| Application number: 2025/92971 | |
| What is the application for?: | Variation of conditions 2 (plans) and 13 (replacement wind turbine) on previous |
| Address of the site or building: | Grange Moor Coachworks, Barnsley Road, Grange Moor, Huddersfield, WF4 4DR |

Projection:		MATERIAL:		REVISION	3
DRANN	NAME	SIGNATURE	DATE	 BESTWATT Am Emsdieleich 7, 26789 Loebe Tel: +49491454100	
CHRD	AV		26-1-2022	Description: Wind Turbine Elevation	
			Color:	Drawing Number WTGANC_002	Part Number Bestwatt 80
			WEIGHT:	Scale: 1:100	A1
					SHEET 1 OF 1

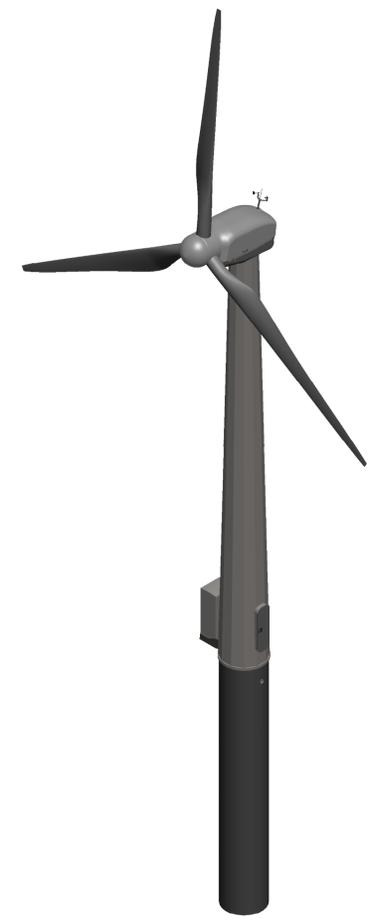
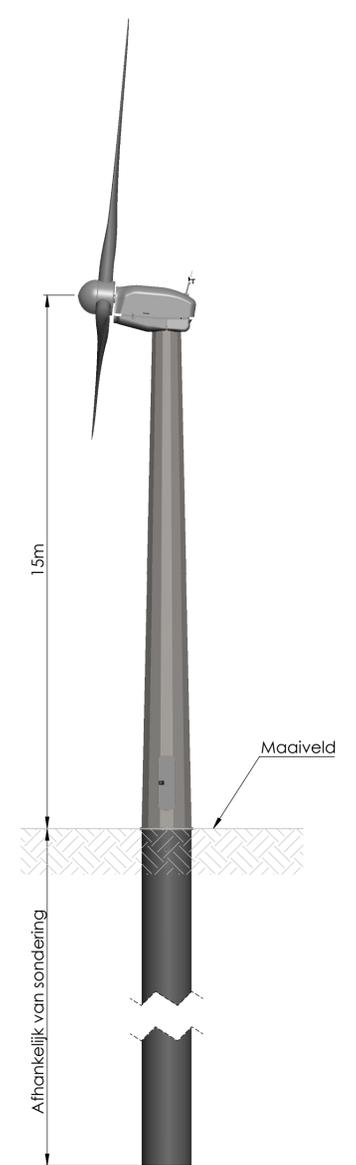
| <p>I would like to make an objection to the proposed increase in height of the wind turbine located at the former Holgate site Barnsley Road Grange Moor WF44DR as it is located only 150 yards from our house and garden. The original turbine was only approved on appeal by someone looking at a plan in an office miles away from our community, the local planning committee that viewed the site rejected it unanimously due to its close proximity to our homes. The existing smaller turbine causes severe flickering and at moderate wind speeds is very noisy, at times it can sound like a helicopter in our garden and conservatory. The specification may look ok on paper but when you live with these turbines noise and flickering daily at the coal face it's very different. The previous owner only sited it there because i had complained about the massive eyesore along with stone crushing and sand blasting in the open at the side of our homes. We would have hoped that the new owner of the site would be more sympathetic to his neighbours, we have already been subjected by default of the last owners misuse of the site to the largest industrial building in the area on a green belt site right outside our small community's homes. My has recently been diagnosed with and our conservatory with floor to ceiling windows and patio are our places of piece and joy whist going through , and I would appeal hopefully to the owners better nature and decency to either site the new turbine on the edge of the coppice of trees on the site, or even at the very south west corner of the site where it wouldn't cause harm to our residential amenities. I would even be prepared to contribute to any extra cost of a more sympathetic location of the proposed or even larger turbine in the best interest of my and i am available any time to discuss it with the new owner of the site, Kind Regards</p> | |
